# KITTITAS COUNTY FIRE MARSHAL'S OFFICE

December 26, 2023

Fire Marshal comments  
3 BR Custom Cuts (Revision)  
CU-23-00001

DATE: November 27, 2023	SHEET: C3.1
SCALE: 1" = 30'	
DRAWN BY: DDR	
CHECKED BY: DLD

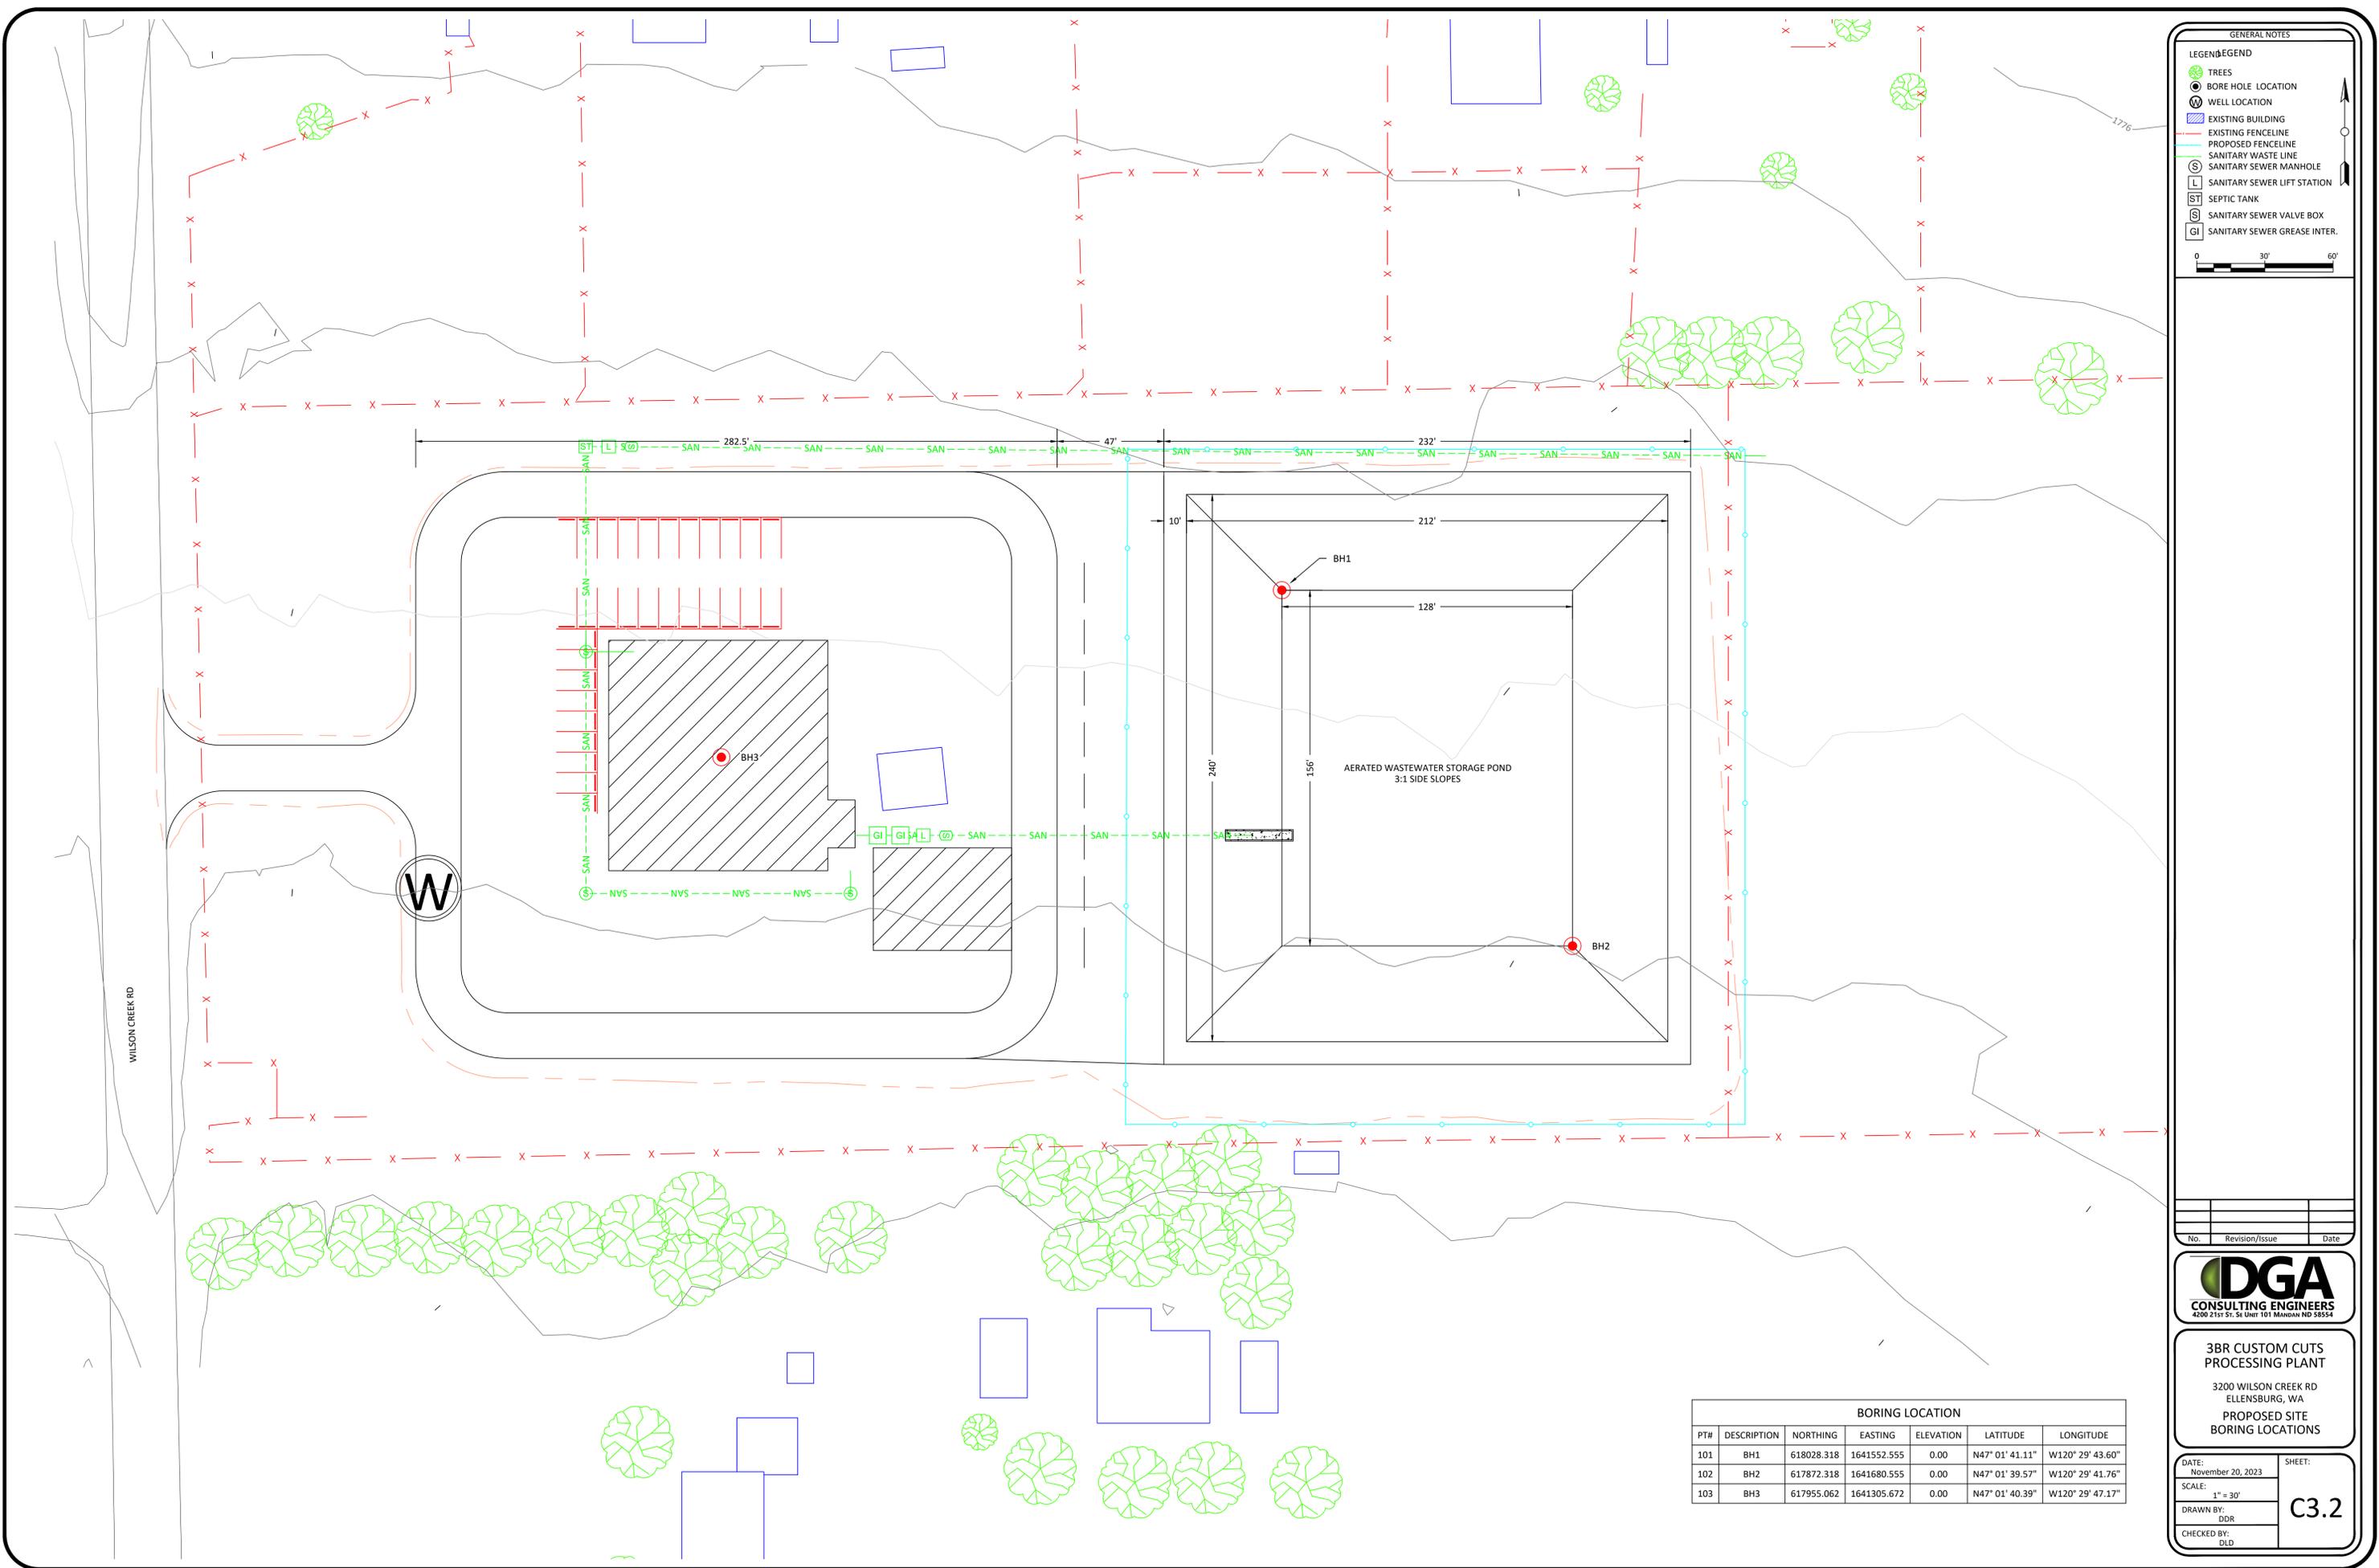
Fire hydrants are required for this application. Either the indicated number or the spacing of the fire hydrants is inadequate. Provide fire hydrants such that the maximum spacing between hydrants does not exceed 450 feet and such that no portion of the building exterior is more than 450 feet from a fire hydrant as measured along approved fire apparatus access roads.

Fire apparatus access is required for this application. The roadways and maneuvering areas as indicated in the application adequately provide required fire apparatus access. Provide fire apparatus access roads with an unobstructed width of not less than 20 feet, an unobstructed vertical clearance of not less than 13.5 feet, with an all-weather driving surface and capable of supporting the imposed loads of fire apparatus. Access roads shall extend to within 150 feet of all portions of the facility and all portions of the exterior walls of the first story of the building.
